**From:** [Maria O'Donnell](#)  
**To:** [Emily Dickson](#)  
**Subject:** HPE CM: SSD 8517 (Condition B29) and SSD 8449 (B25) - Modification 1 - Conditions relating to Stormwater Quality Assessment at the Locomotive Workshops, South Eveleigh - Council's Response  
**Date:** Wednesday, 24 April 2019 4:24:54 PM

Thank you for the opportunity to comment on the proposed modification to the wording of the respective Storm Water Quality Assessment conditions under SSD 8517 (Condition B29) and SSD 8449 (B25). This response is in relation to both SSD modification applications.

Figure 1 Proposed Locomotive Workshops Stormwater Treatment Train

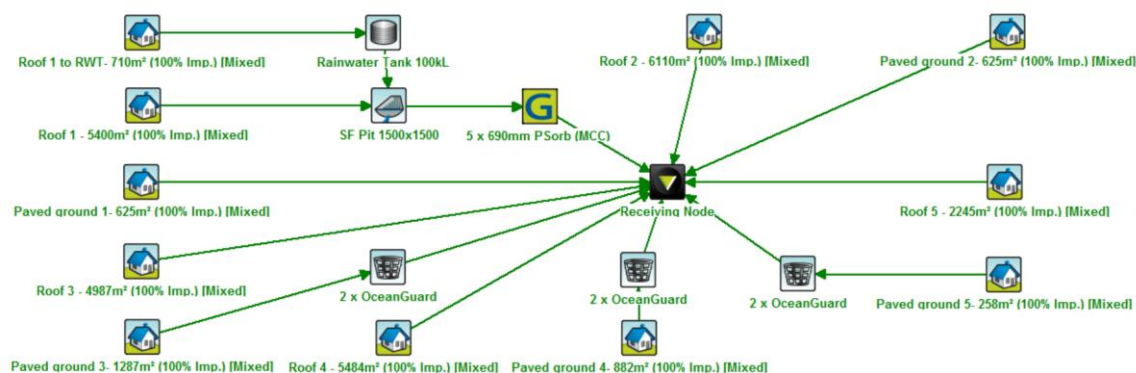
The proponent is seeking to significantly lower the standards to 25% (90%), 30% (85%), 10% (65%) and 10% (45%). The numbers in brackets are the DCP target standards. It is our understanding that the proponent's reasoning for the changes is that the existing buildings and storm water drainage system will remain unchanged and they have only considered a storm water treatment system comprising filter baskets being installed within the existing gully pits to remove pollutants from the storm water runoff.

The City does not support the proposed modifications and consider that the wording of the relevant conditions should remain unchanged. The Department are advised to request the proponent to consider a storm water treatment system incorporating new Gross Pollutant Traps and similar storm water quality improvement devices that will enable the specified targets to be met.
